**From:** Jeff Tarling  
**To:** Helen Donaldson  
**CC:** David Margolis-Pineo  
**Date:** 12/5/2014 11:54 AM  
**Subject:** Brighton Avenue / Hampton Inn Project

The proposed Hotel Development project proposed for Brighton Avenue tree & landscape review comments:

7 WOOD FENCE DETAIL
C4.5 NOT TO SCALE

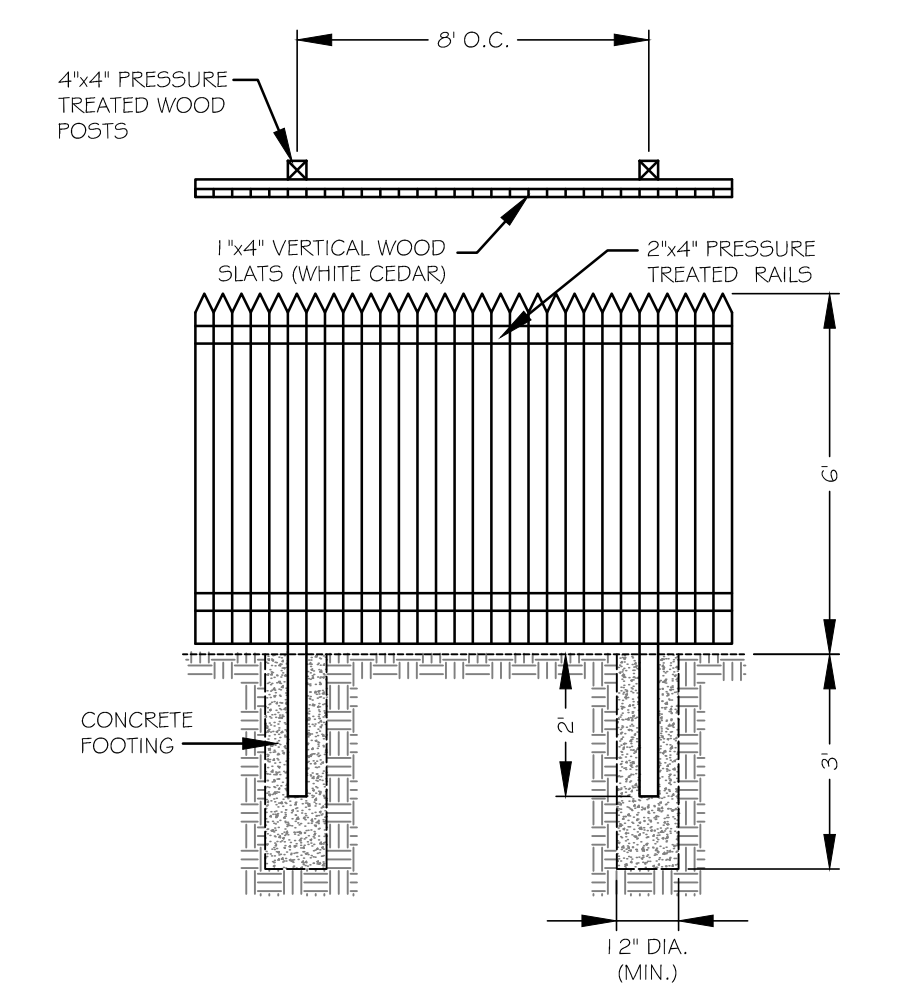
c) Project view from Brighton Avenue should be improved screening with increased tree / landscape buffer between proposed hotel and existing lots fronting on Brighton Avenue. This should include a low solid wood fencing or black vinyl chain link 5' minimum height. The proposed entrance drive and the shared space with Denny's should be defined and approved with landscape treatment to the extent possible to better define entrance.
